CROSSROADS NORTH PRELIMINARY PLAN

LOCATED IN THE EAST 1/2 OF SECTION 8, T14S, R65W, OF THE 6th P.M., EL PASO COUNTY, COLORADO

PCD FILE NO: SP207

Preliminary Plan Drawings_v2.pdf Markup Summary 6-23-2022

D STREET LANDSCAPE DETAIL "D-1" - MARKSHEFFEL ROAD  
TYPICAL NTS

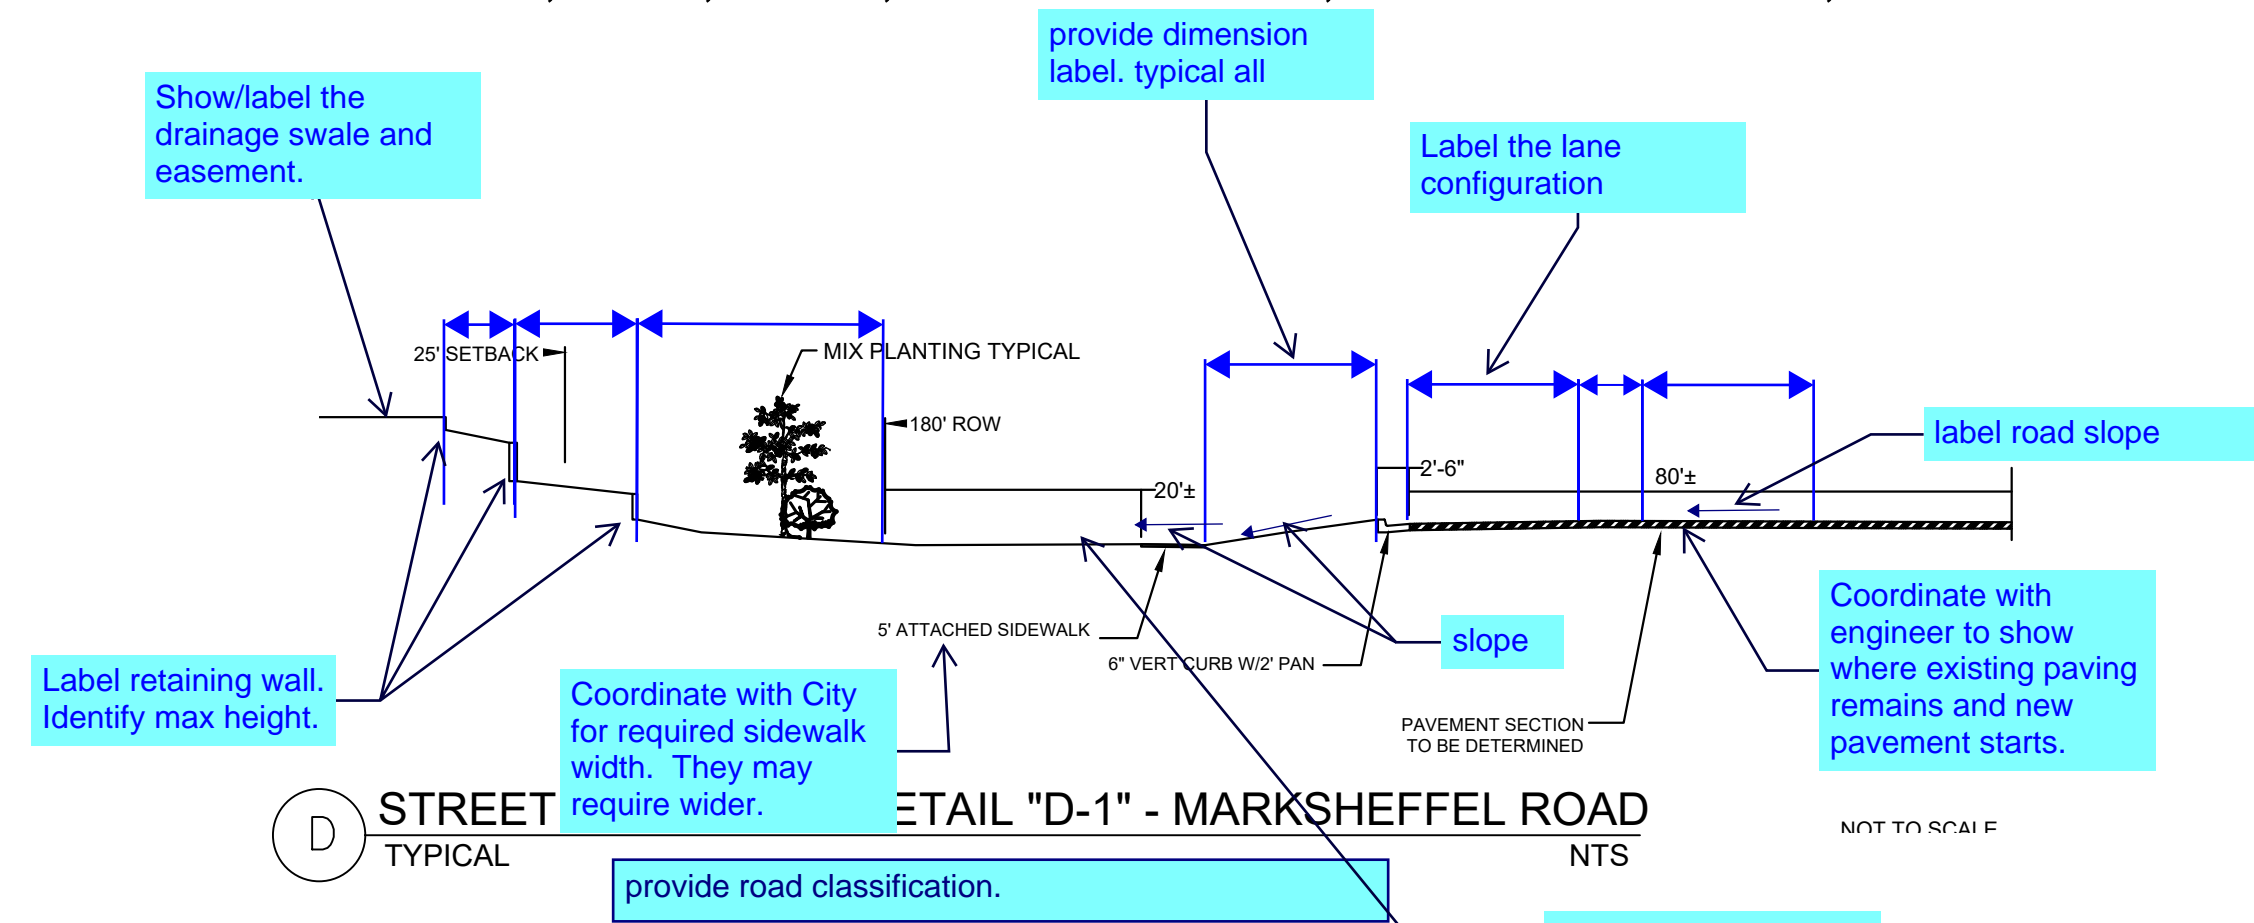
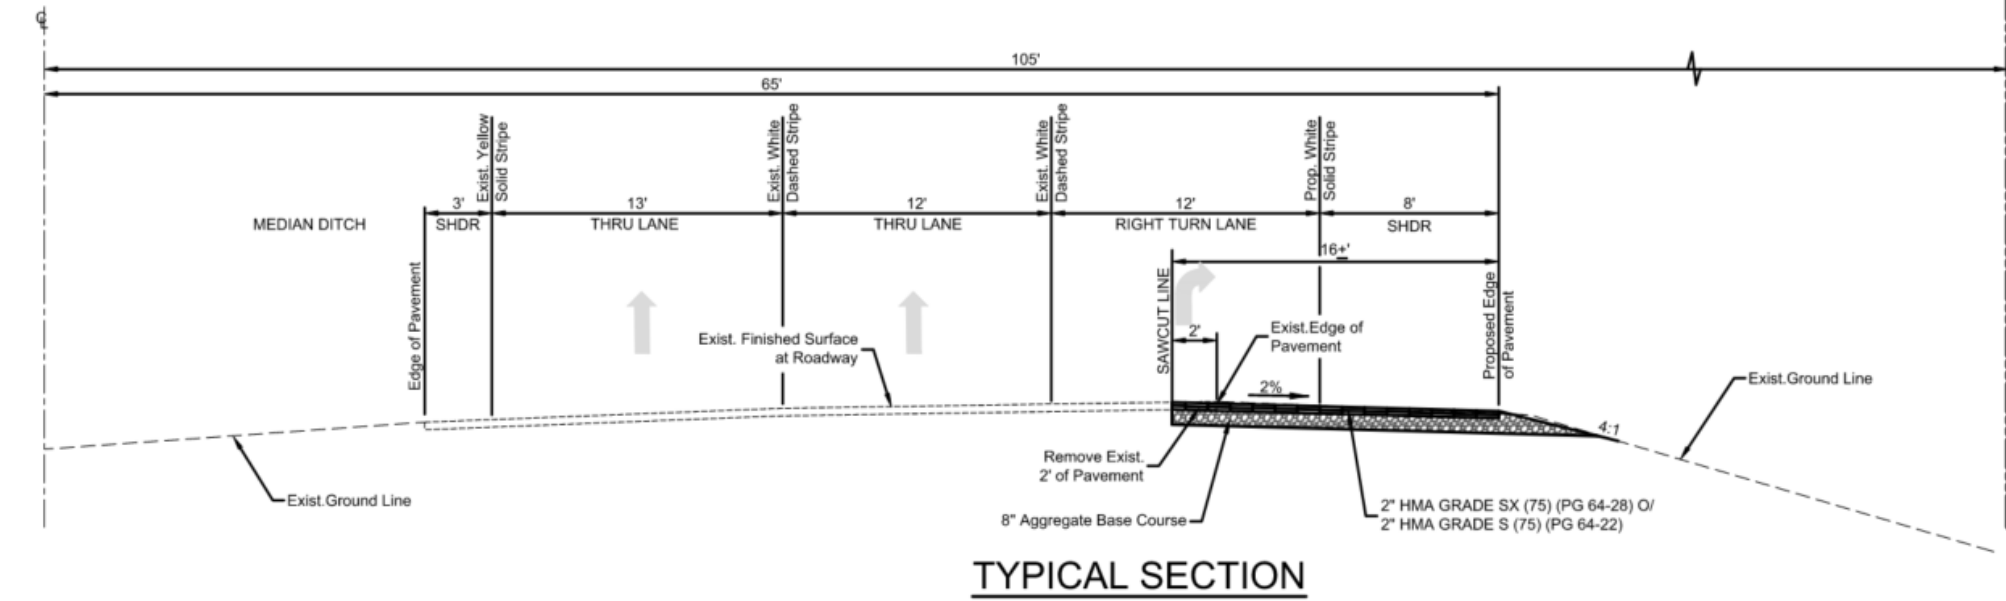
identify the max height of the retaining wall.

Sheet 2 appears to indicate two tiers of retaining wall. Update to reflect the grading plan.

Review #1: Label lane widths and street/sidewalk cross slopes. Typical for sections B, C, & D

Revise. Marksheffel is Urban Principle Arterial.

Revise cross section. This needs to identify what is new and what is existing. Multiple cross section needed. One where a new southbound Right turn is added. Another where a northbound left turn is proposed. See snippet to the right for example.

Revise to match the site plan which shows detached sidewalk.

PRELIM PLAN 2
SHEET 03 OF 14

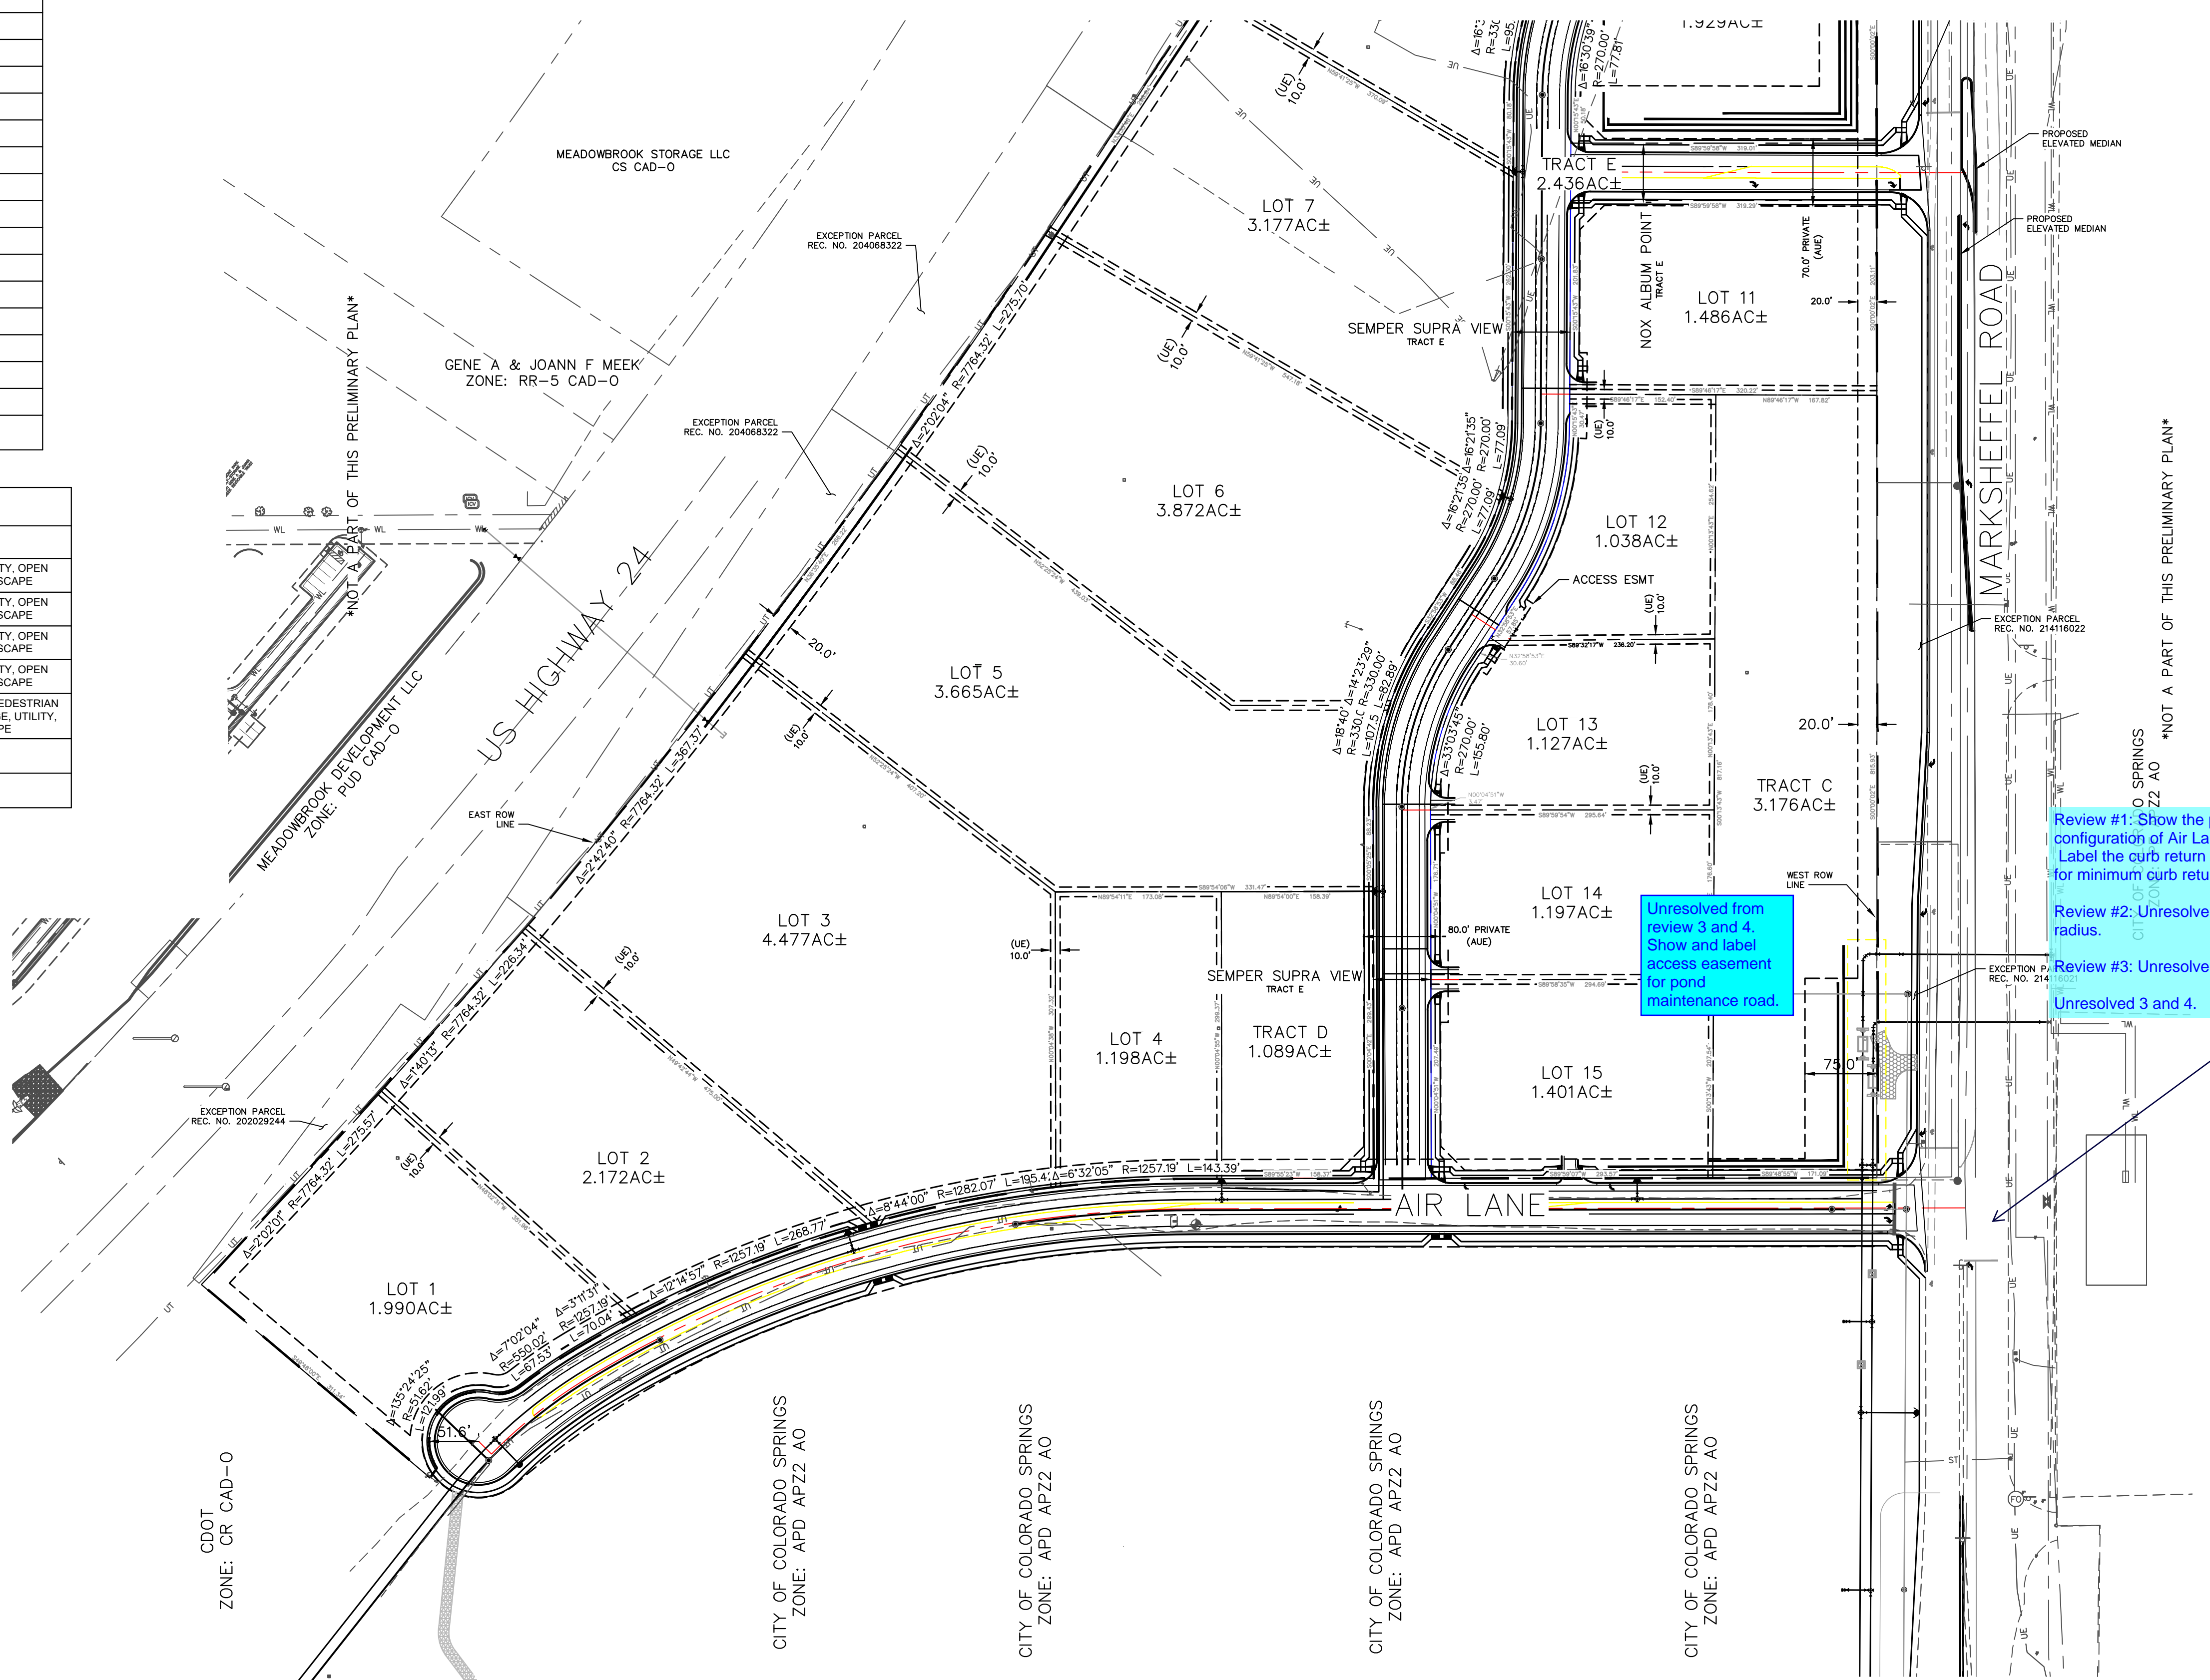
Label proposed SBRT

Shift the proposed right turn arrow to the west.

Shift the proposed right turn arrow to the west.

Provide typical cross section. Cross section to include the pond

Provide typical cross section.

Label proposed NBLT

Revise to Right-In/Right-Out.

See comment on the deviation request. The deviation request is likely to be denied.

Update the cul-de-sac bulb radius to match the County detail SD_2-75

What is the purpose of the notch in the ROW line?

Label access and in your own words add a note stating access to Lot 2 is limited to this access.

Label the P.I.E. The Hillcrest Acres subdivision plat (Plat No. 1950) does not show this easement therefore reference the document/reception # that established the easement.

If this is proposed easement then the applicant will need to acquire the easement before the deviation request will be approved.

show/label the access easement through Lot 7 for the pond maintenance road.

Review #1: Show the proposed roadway configuration of Air Lane and the intersection. Label the curb return radius. See Table 2-31 for minimum curb return radius.

Review #2: Unresolved. Label the curb return radius.

Review #1: This appears contradictory. The roads are both identified as tract and easement.

Review #2: Unresolved. If it's already a tract with the identified use then an additional easement shouldn't be required.

Taper length does not meet criteria or the TIS recommendation. Revise and provide dimension label for all turn lane striping and taper length for all proposed locations.

Provide a larger detailed preliminary grading at the intersection. There appears to be drainage issues with two existing culverts, proposed sidewalk and existing roadside ditch.

Provide typical cross section. Cross section to include the channel
